Subject: Planning Application 2021/90800
Date: 15 March 2021 15:32:33

| Drawing Overall Site Plan | |

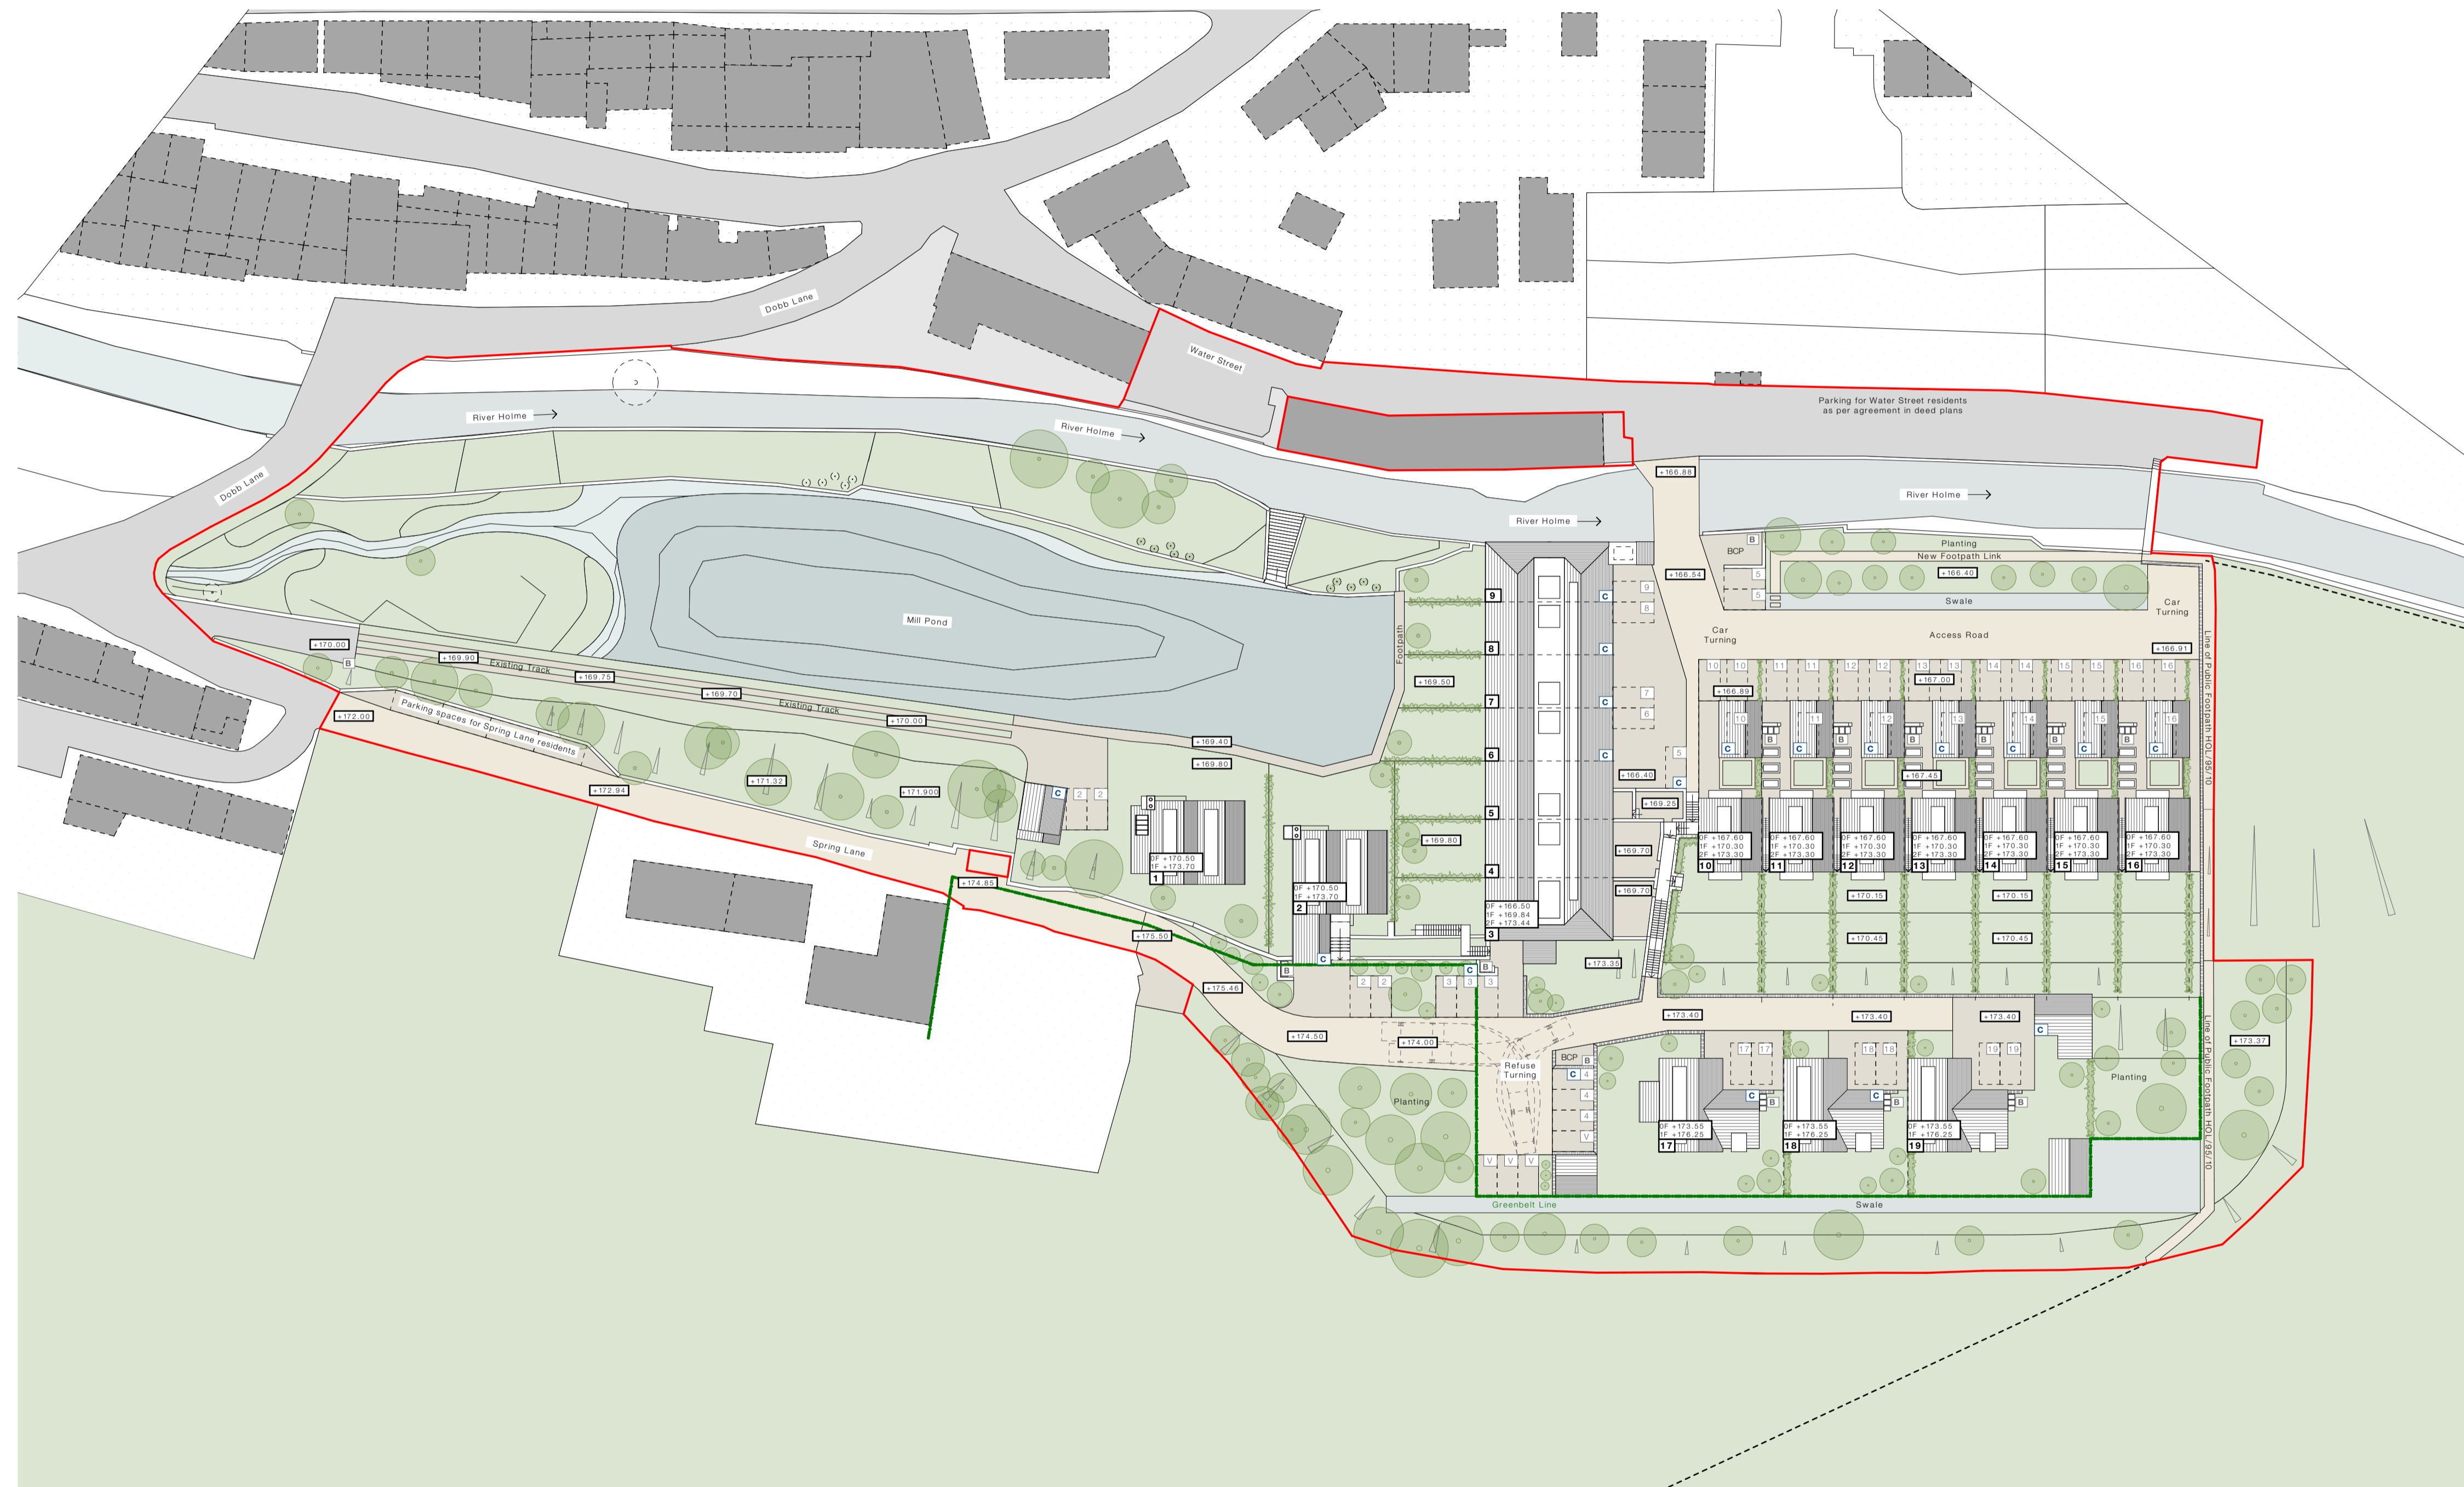
My main concern regarding this planning application is access/egress to the site for emergency response vehicles and also the increased traffic volumes in an area which has narrow road infrastructure.
